MEMORANDUM

DATE: February 15, 2024

SUBJECT: PUDSP-21-010 – Grandview Reserve (with PSSG)  
Eighth Submittal (“V11”)

GRANDVIEW METRO DISTRICT
 CHANNEL B GRADING

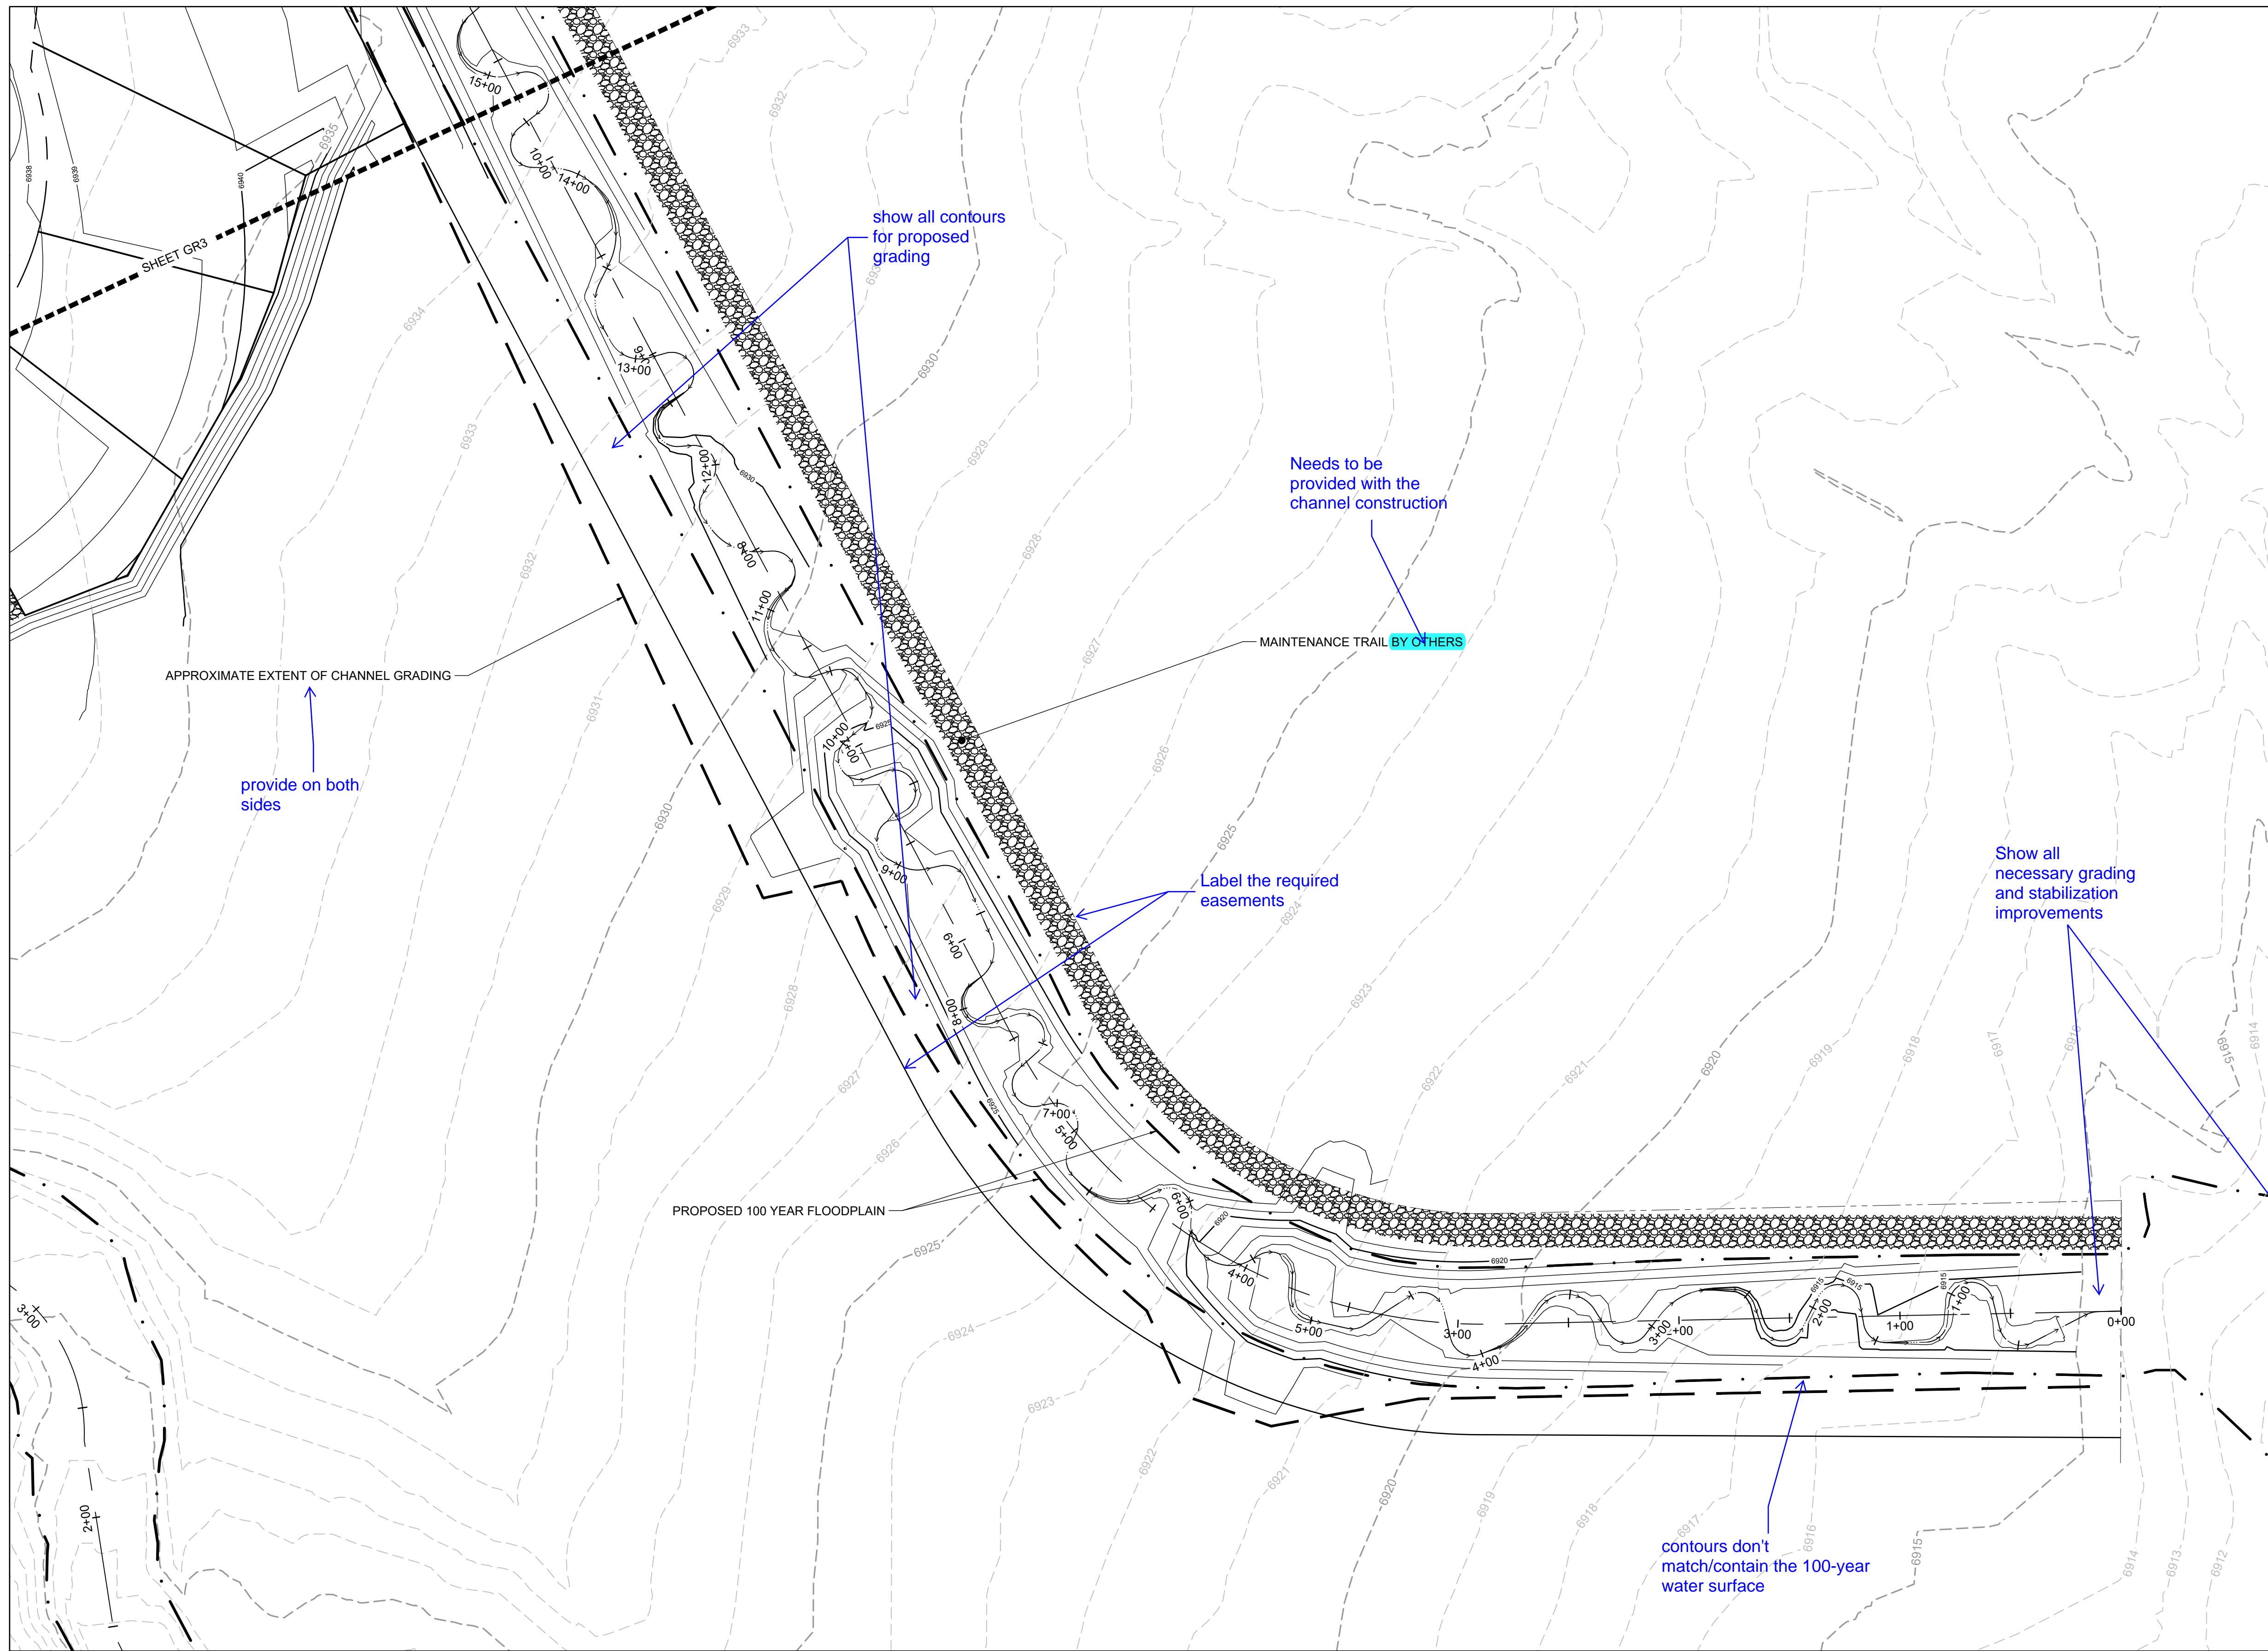
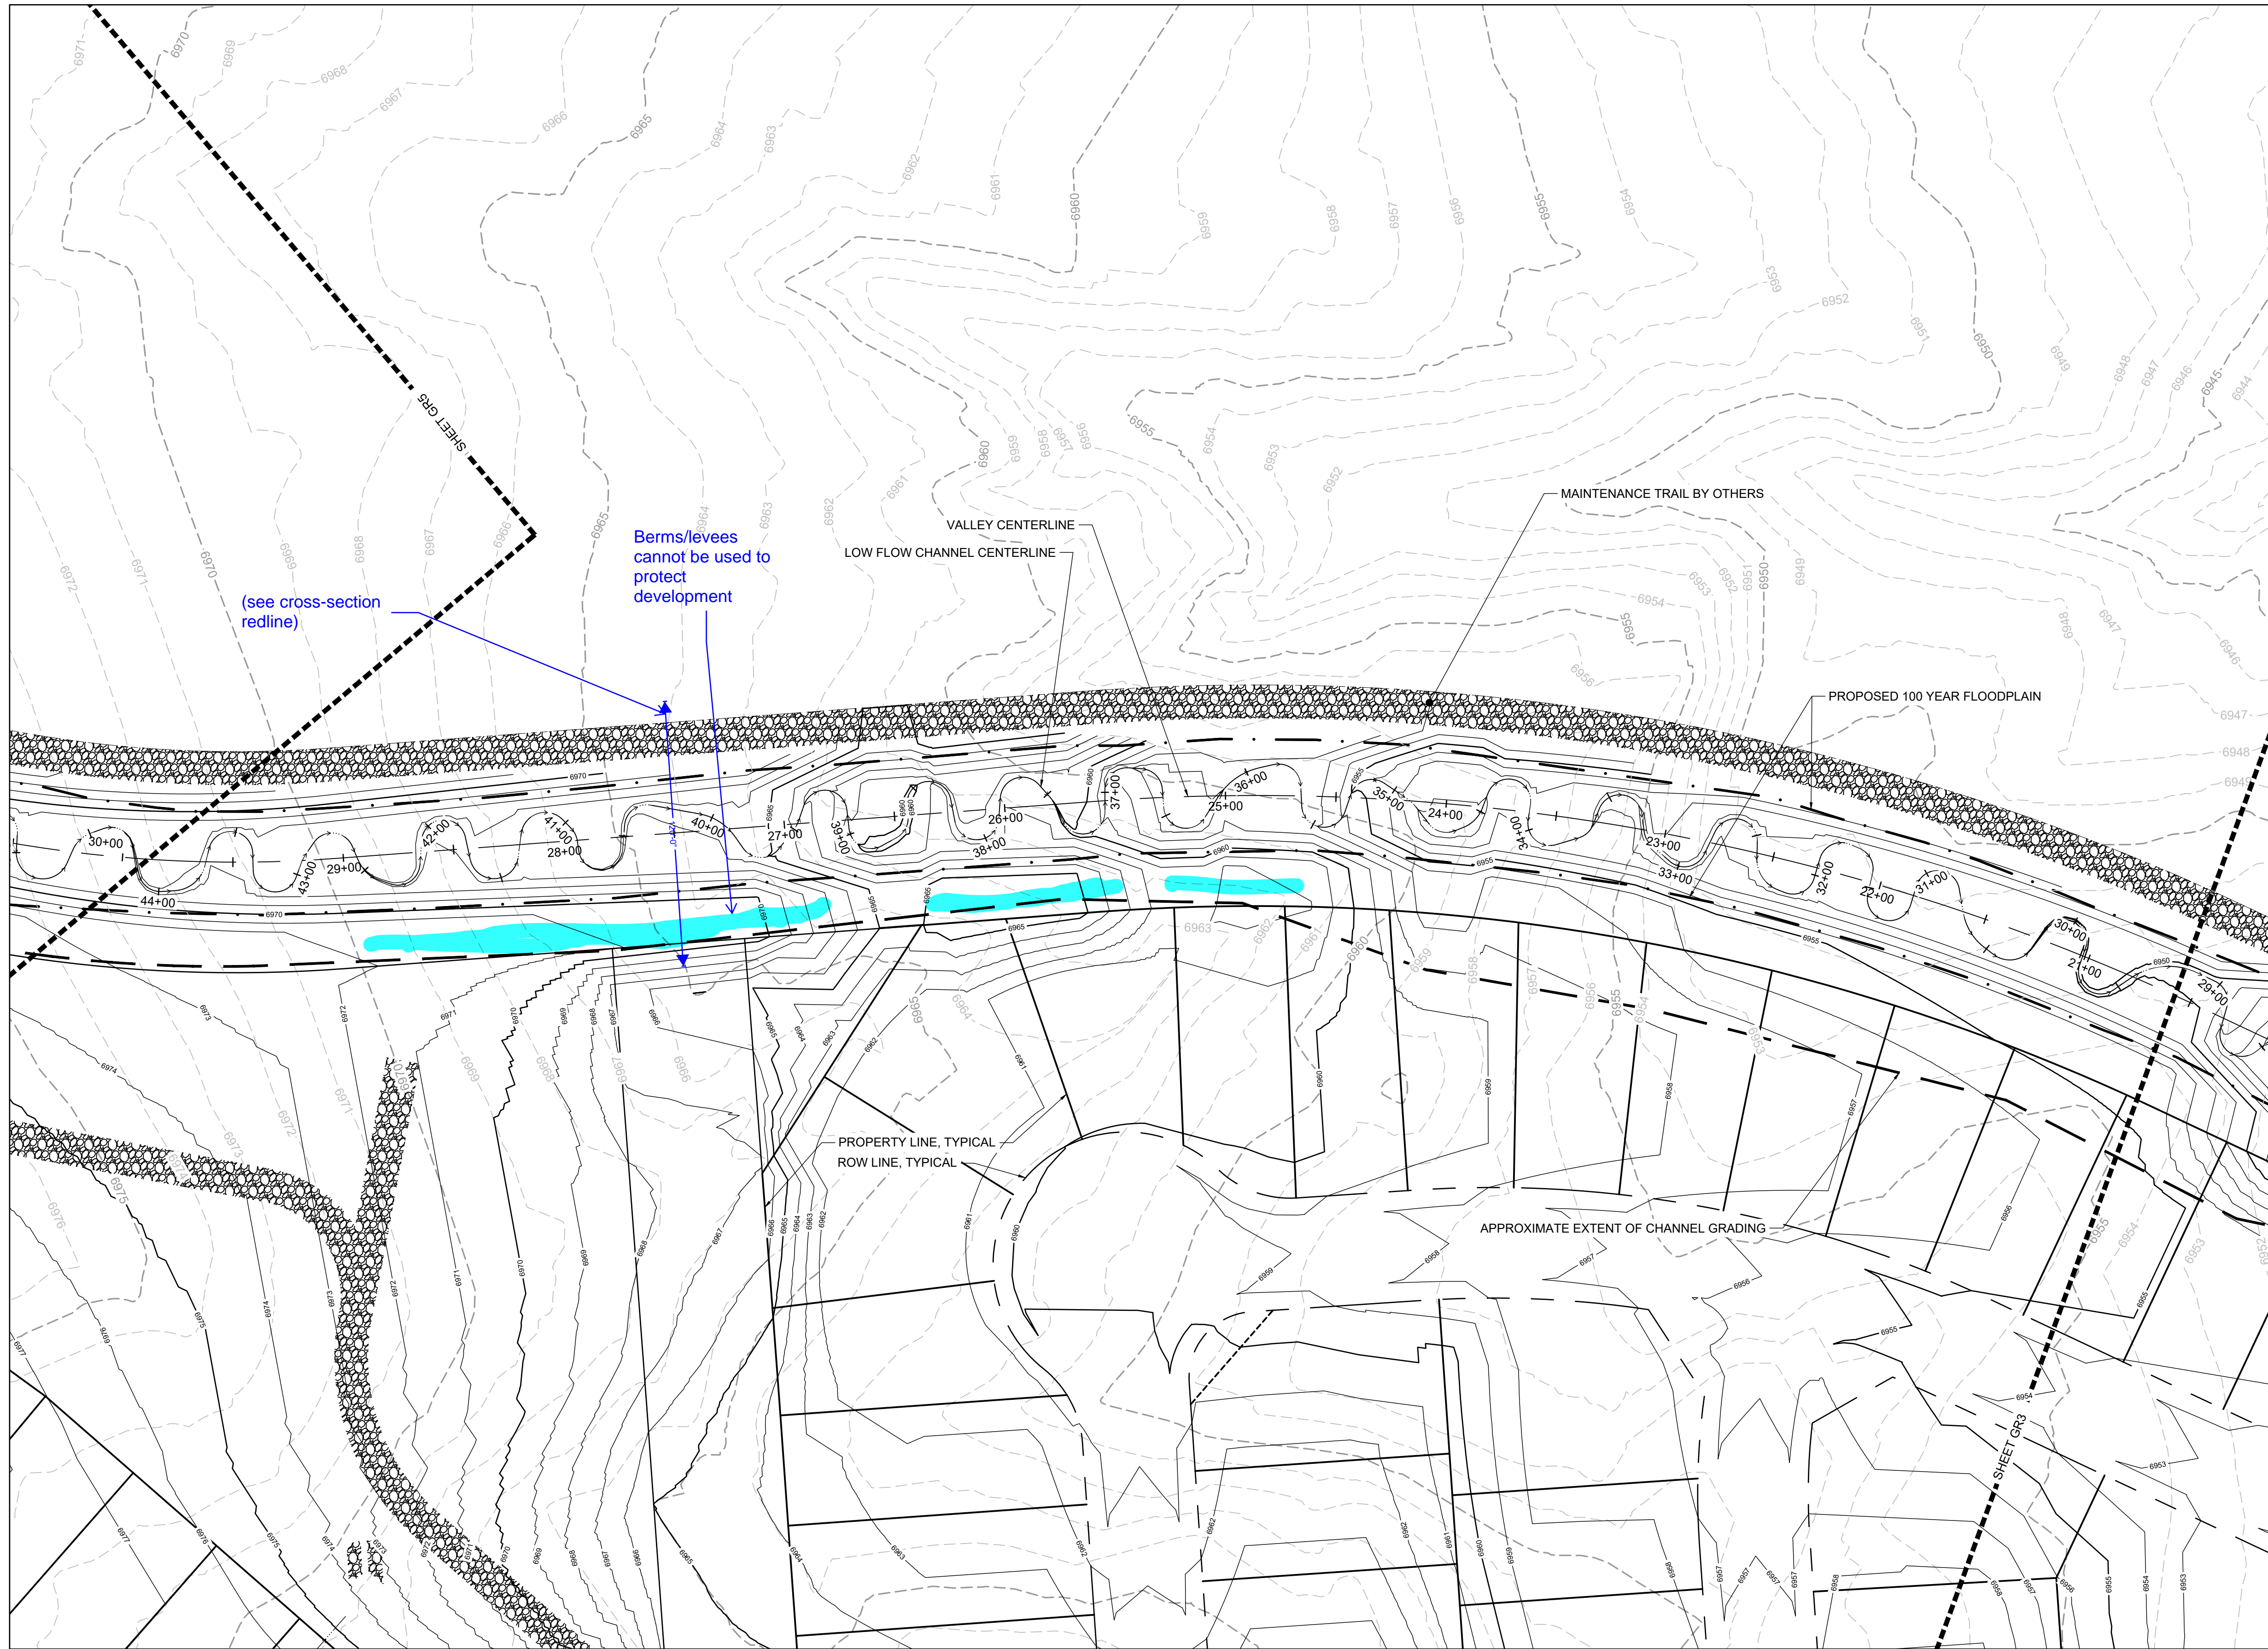
- a. Regarding the "Summary and BOD" document, see email dated 10/8 with cursory comments:
    - i. The cross-section template appears to have been run through the whole channel alignment, creating berms along the channel in some locations. I just want to verify that those will be graded out or widened where appropriate. (see attached redlines highlighting some of the areas of concern). Partially resolved; the grading needs to be completed. **(To be reviewed under CDR-22-008)**

- a. Resolved.
  - b. Berms/levees along the channel next to development areas need to be removed and if fill is added to contain the floodplain it needs to be graded out to an even surface from the edge of the channel (reference CWCB and USACE regulations). **Partially resolved; the very southeast end of the channel is still of concern, with the proposed future Waterbury lots to the south. (To be reviewed under CDR-22-008)**
